From: Chris Wentworth
Sent: 20 June 2023 15:05
To: DC.Consults
Subject: FW: 23/00667/REM - OS Parcel 6372 South East Of Milestone Farm, Broughton Road, Banbury

From: Tim Screen <Tim.Screen@Cherwell-DC.gov.uk>
Sent: Monday, June 19, 2023 7:31 PM
To: Chris Wentworth <Chris.Wentworth@cherwell-dc.gov.uk>
Subject: 23/00667/REM - OS Parcel 6372 South East Of Milestone Farm, Broughton Road, Banbury

Apologies for the delay in responding. Further to submission of the amended landscape proposals (15.062023 I comment as follows:

Project details including scheme name (Balmoral Avenue Phase 2), client (Orbit Homes), drawing title (Landscape Proposals), date (February 2023), scale (1:200@A1), drawing number (ORB24157-11A Sheet 1 of 4), and drafter (TC) checker (SR).

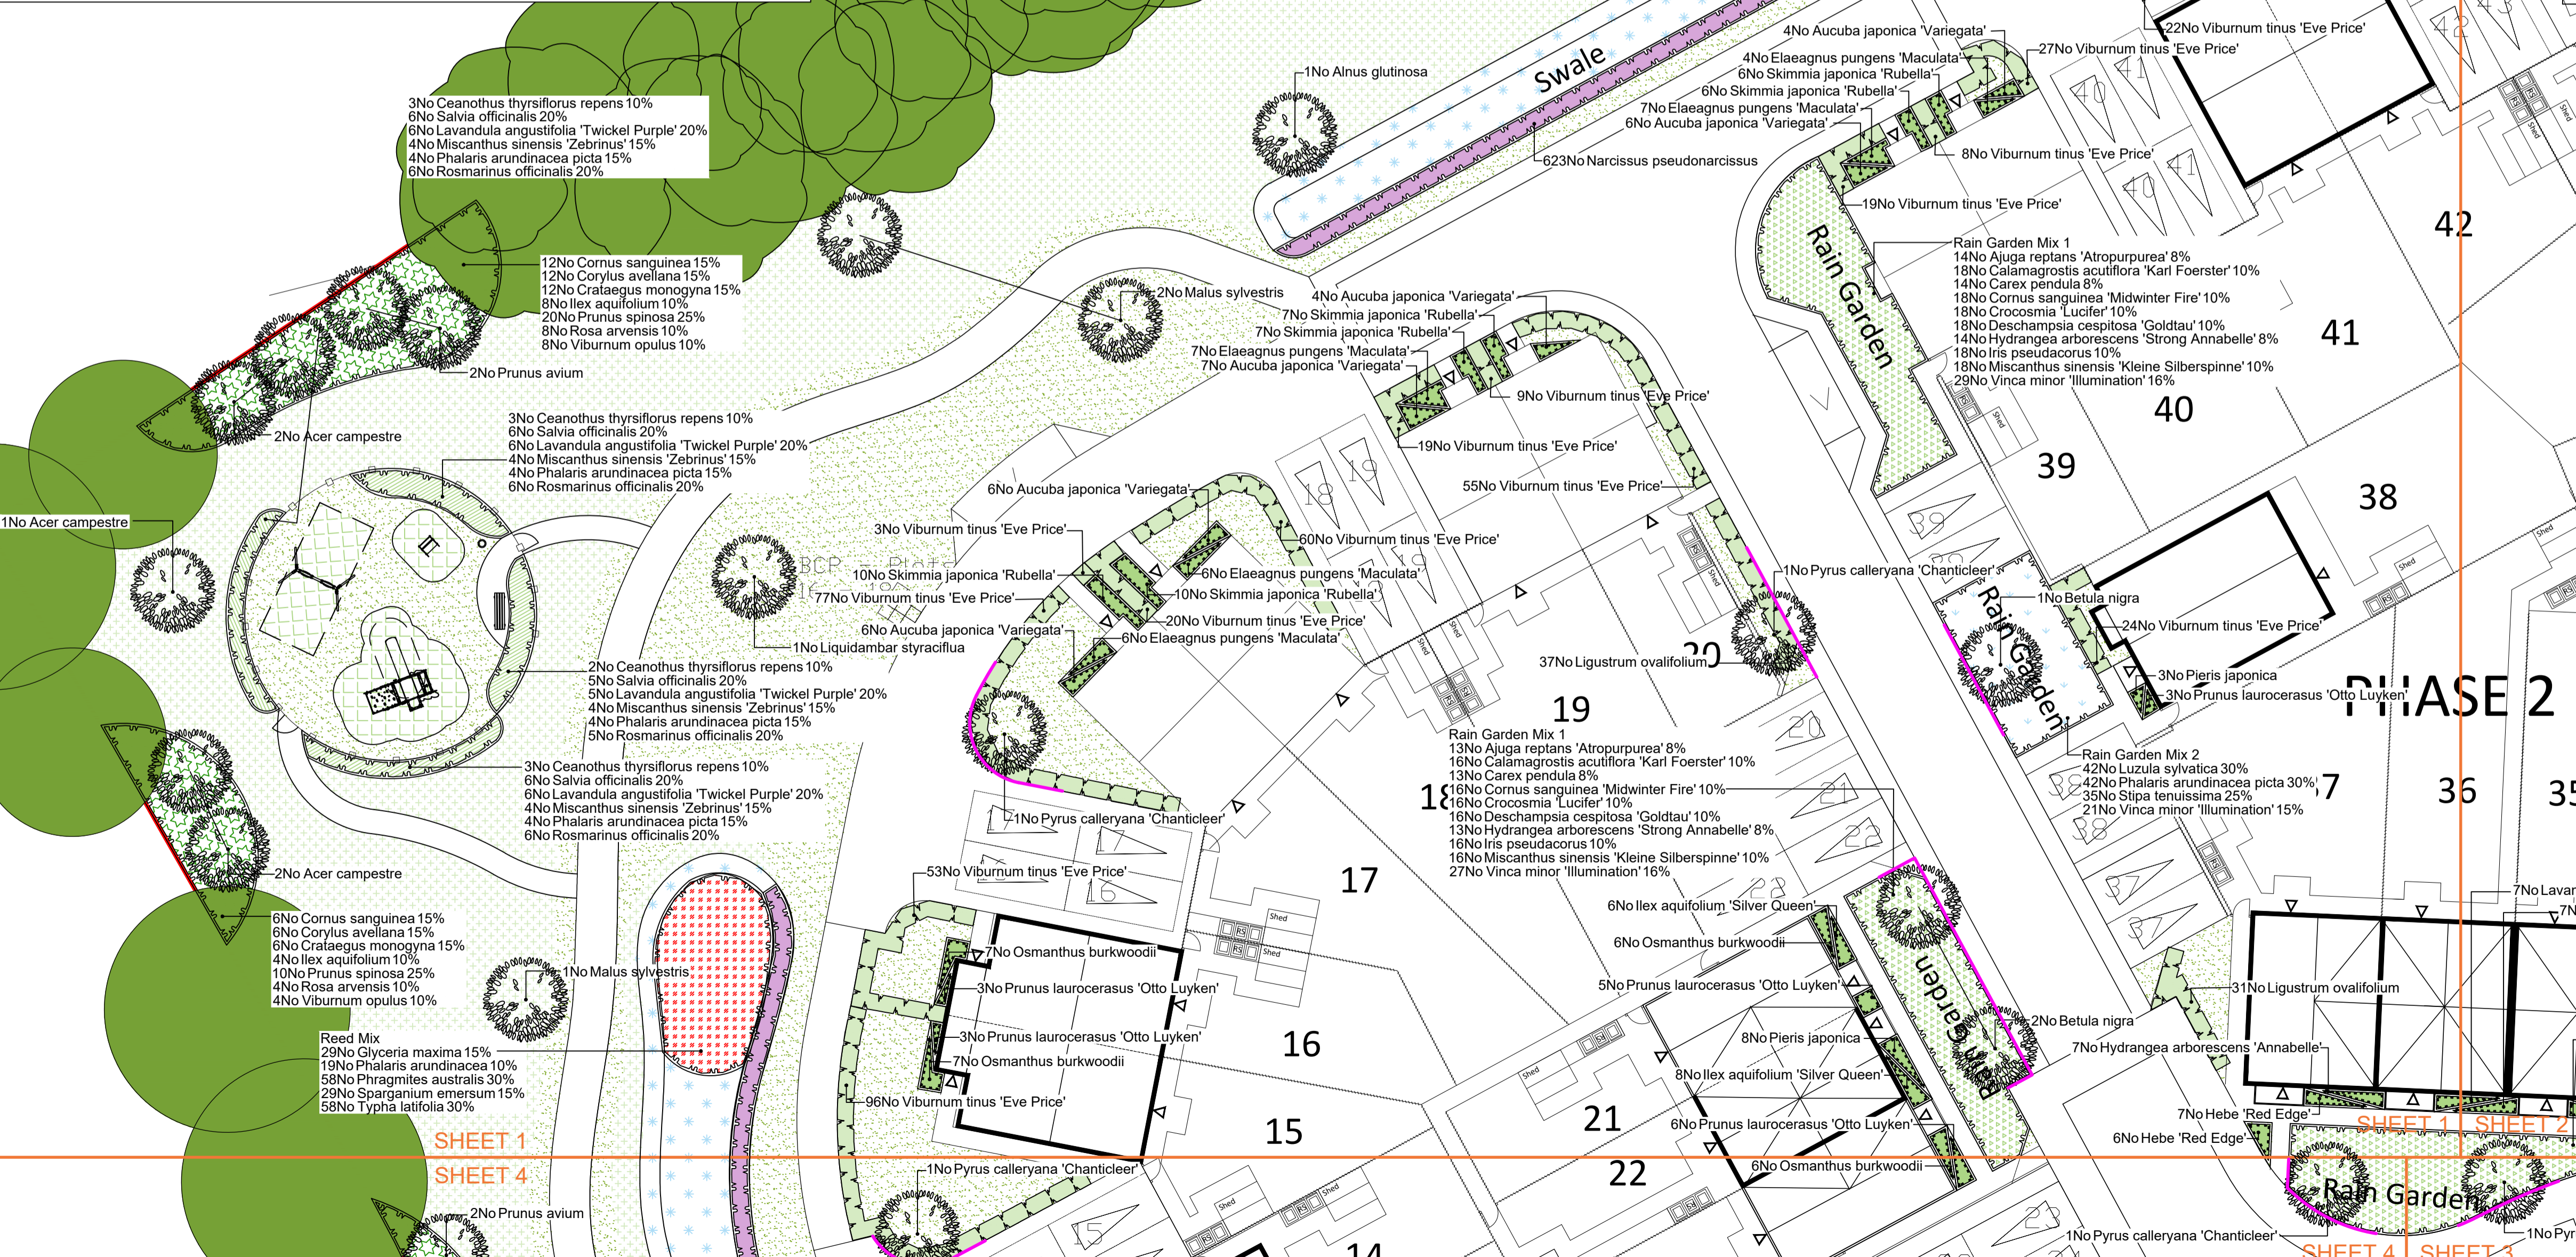
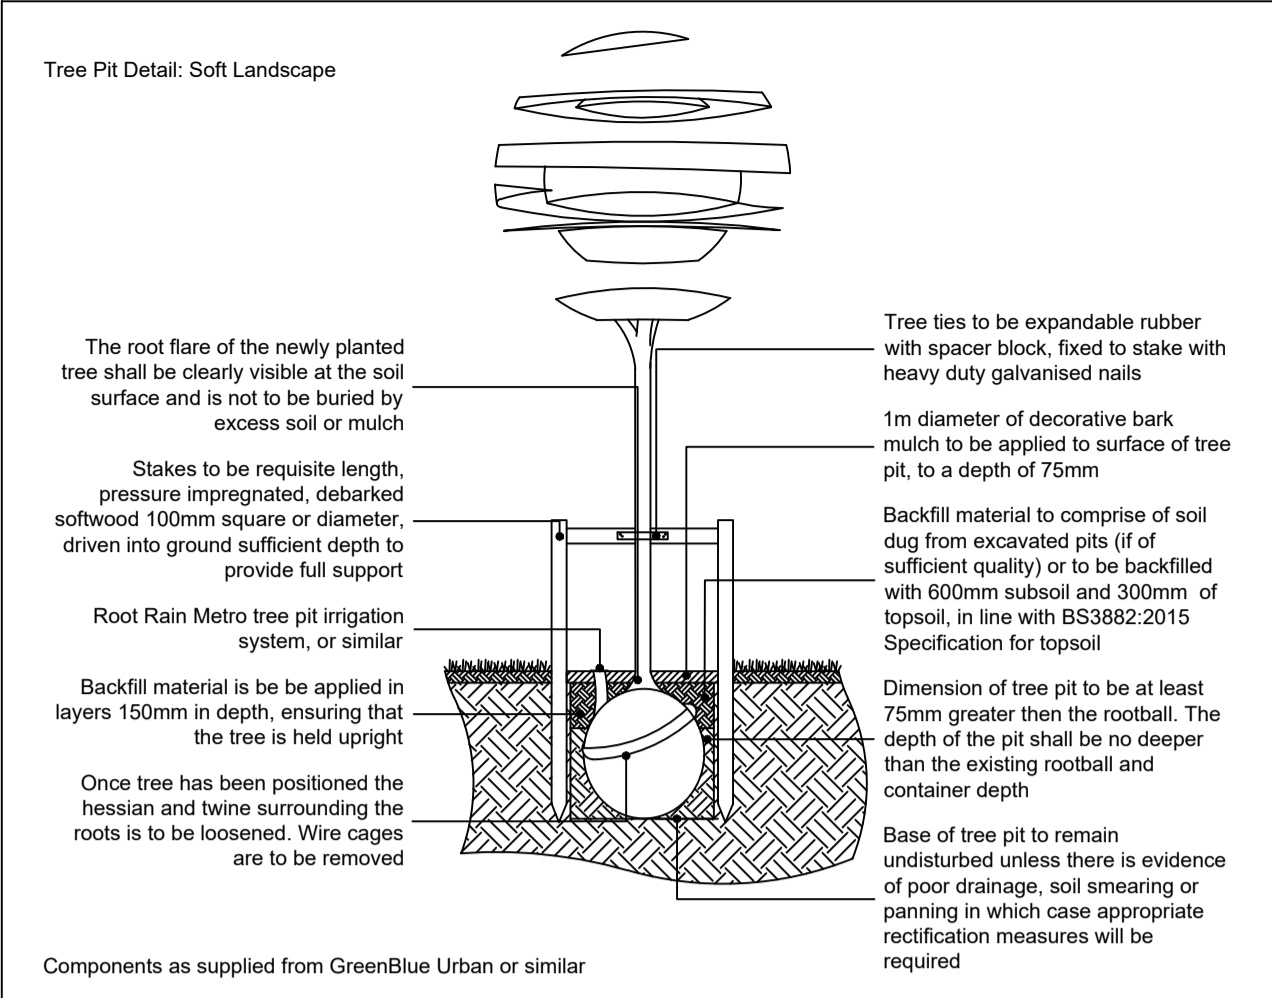
The construction and materials for the POS and play area paths must be confirmed with detailed a construction drawing where macadam with pcc edging are proposed to be used. Gravel or hoggins with timber edging are unacceptable because of the maintenance and refurbishment issues associated with these materials.

I realise that in order to prevent vehicles from driving/parking on POS. Knee rail to be installed with posts set at 1.4 m apart. This is to prevent vehicle access if posts/rails are removed. Contractor's maintenance access to be incorporated into the knee rail with a padlocked timber rail.
